CITY OF ALBUQUERQUE

November 19, 2014

**Re: 3440 2nd Street NW
Grading and Drainage Plan
Engineer's Date 10-31-14 (G14D087)**

DRAWING:	DRAWN BY:	DATE:	SHEET #
201424-GR.DWG	SH-B	10-25-2014	C102

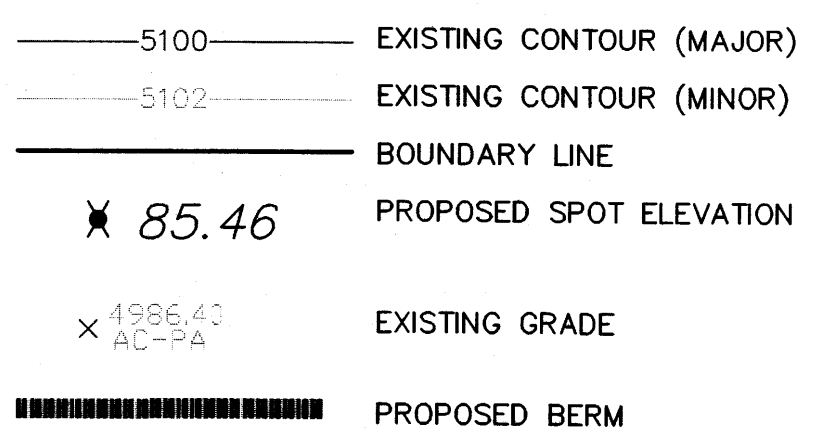
1. A pond is being shown with a top elevation of 4973. The surrounding elevations are as high as 4975. Provide tie-in contours. They should be at less than 3:1 slope in relationship to the pond. Also show how existing grades are being tied into on the full length of the east side of the property. Will there be a steep slope along that edge?

2. The First Flush was not discussed. Per the City Drainage ordinance, the 90th Percentile Storm Event, which is 44 inches, is to be managed. Reduce 0.44 inch by the 0.1 inch for the initial impervious abstraction in Table A-6 of Section 22 of the DPM. Multiply the remaining 0.34 inch by your impervious area. This is the amount of the First Flush necessary for the site. Show that amount on your plans. State that the capacity provided by the proposed pond is greater than what is required for the First Flush.

3. Provide a discussion of the 100 Year Flood Plain.
4. In the AHYMO run for the historical condition, the existing flows should reflect an impervious area that is greater than 40%.
